4th. September, 2018

PLANNING APPLICATION.....APPLICATION NO. M/92/18/HH
Replacement two storey rear extension, balcony and alteration (re-
submission following M/62/17/HH) at 2, Elmer Court, Elmer Sands,
Middleton-on-Sea

Ground Floor Plan

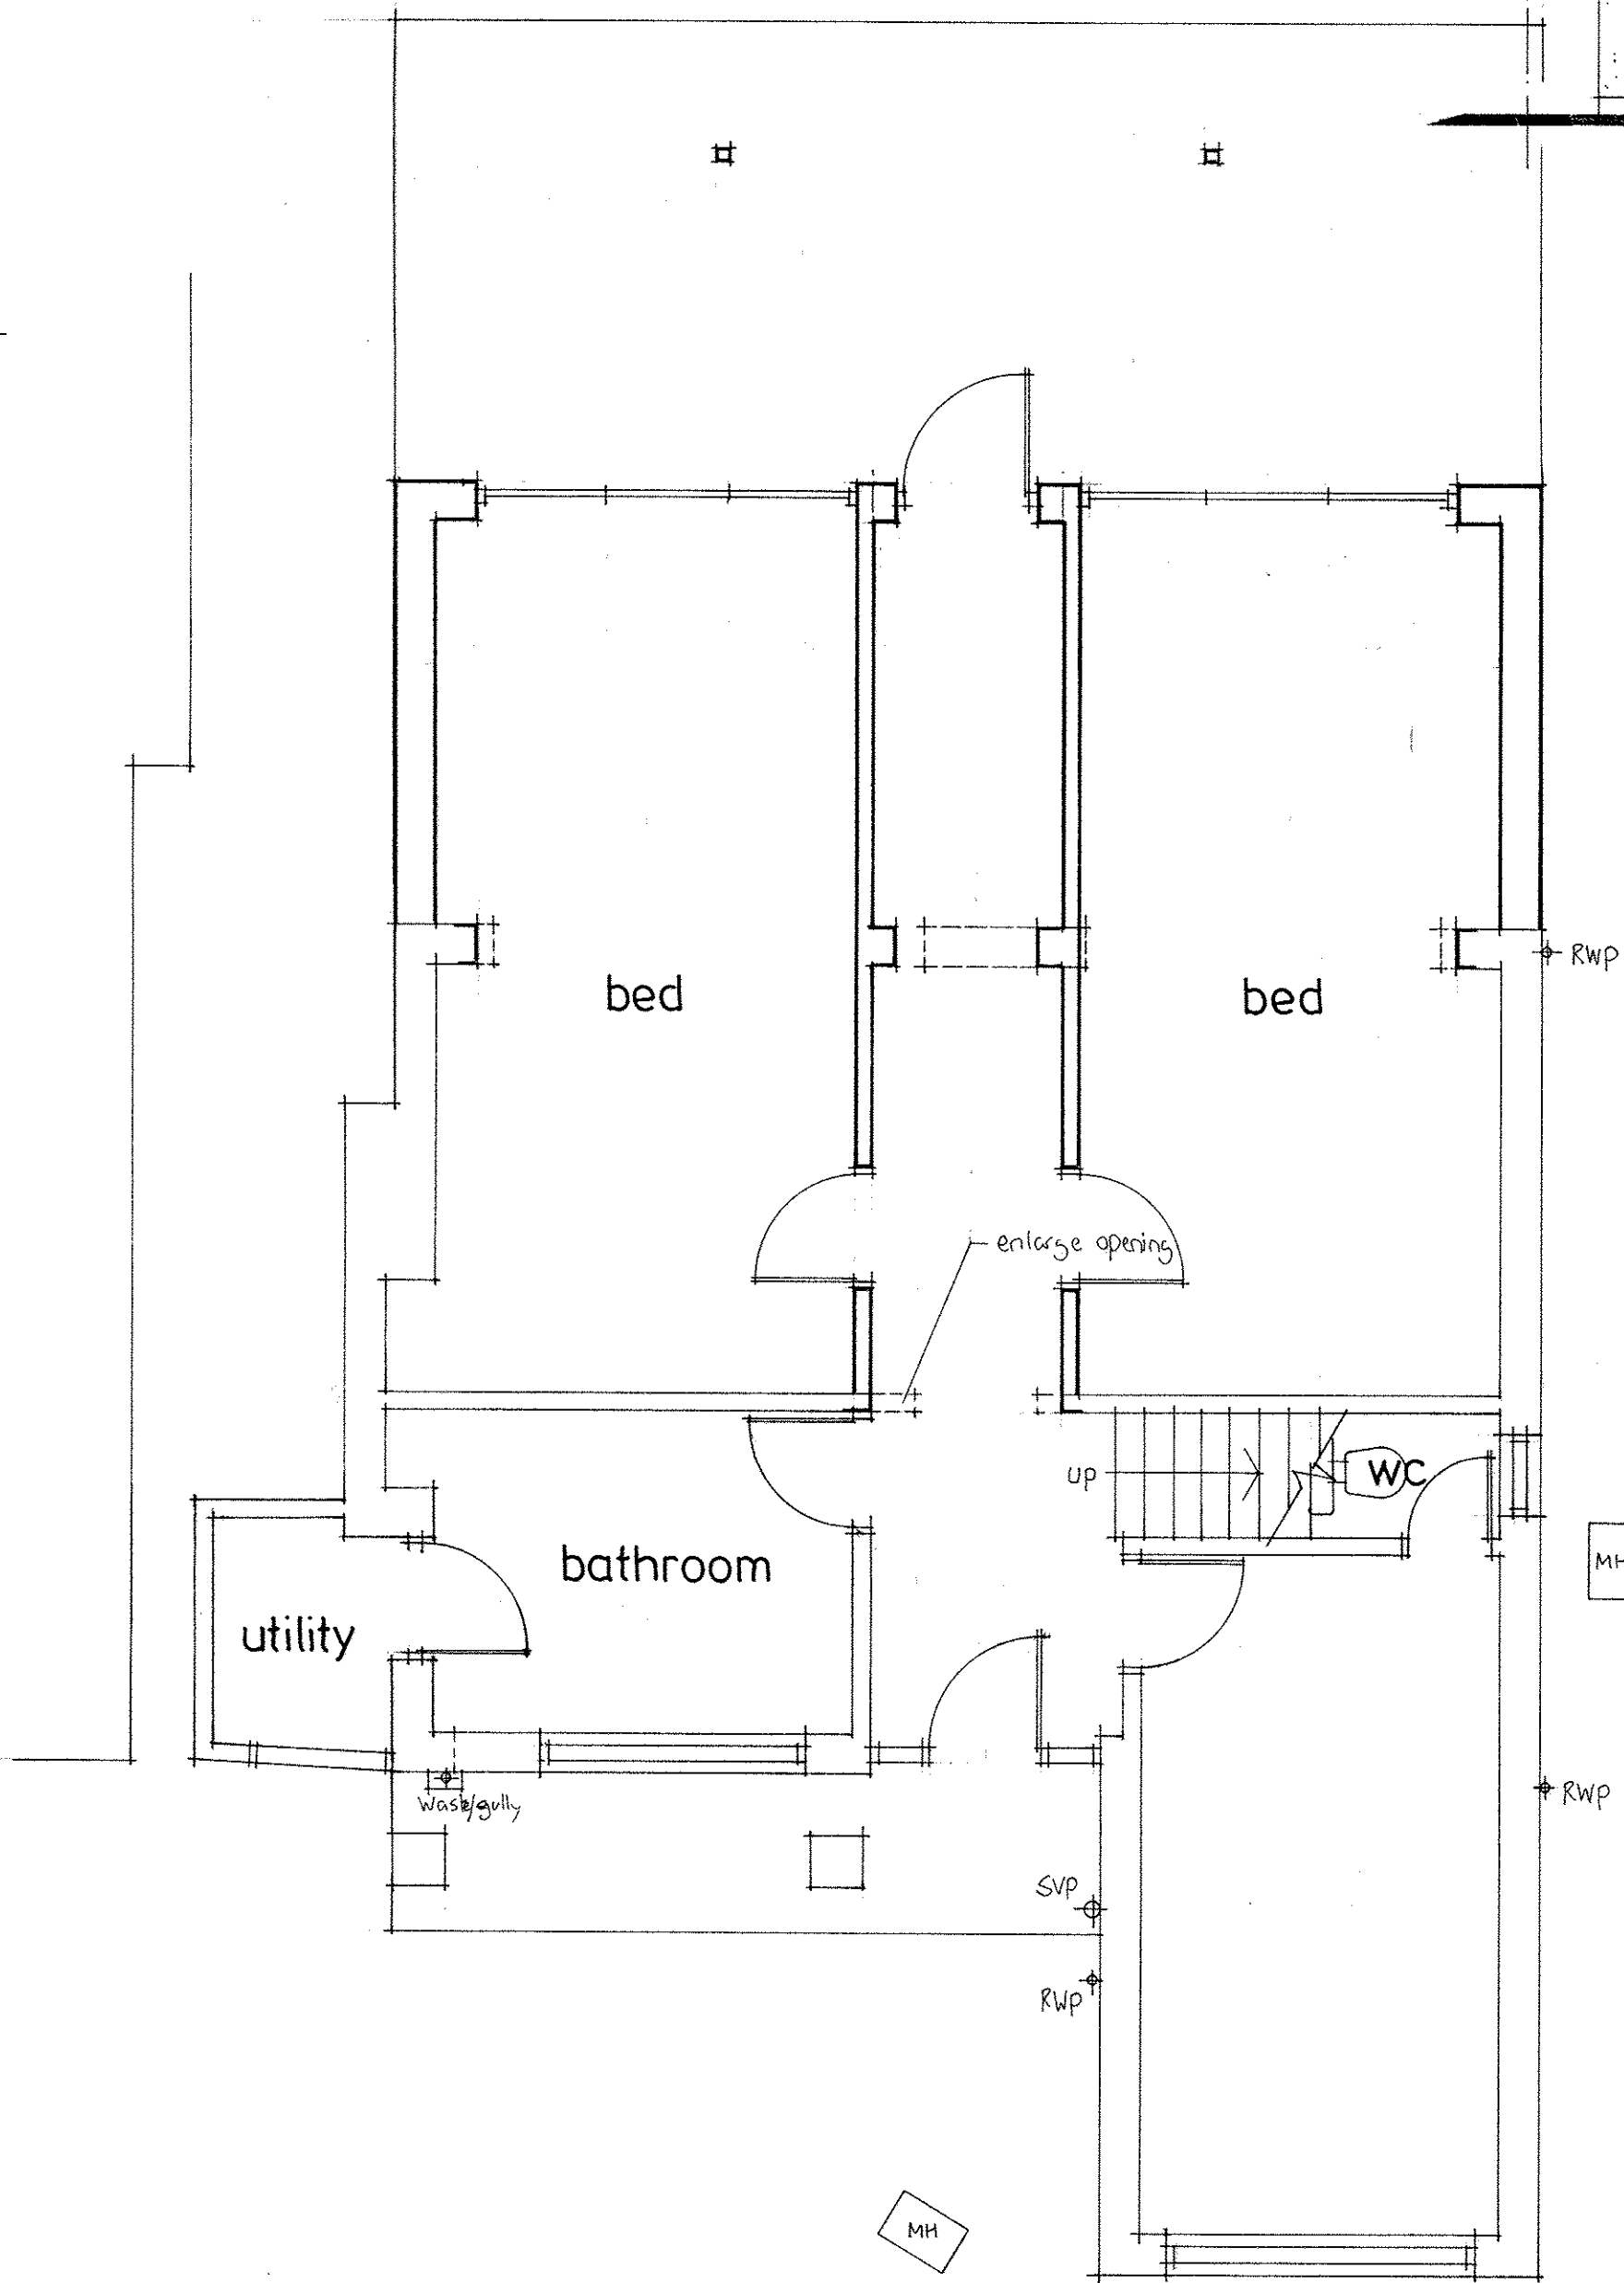
In actuality, the footprint is now slightly larger. The flank walls to the flat roofed two storey extension are now in line with the flank walls of the pitched roof two storey part. Originally, they were set back from the line of the walls to the pitched roof two storey part. (v.i.z. there was originally a return on both flanks.)
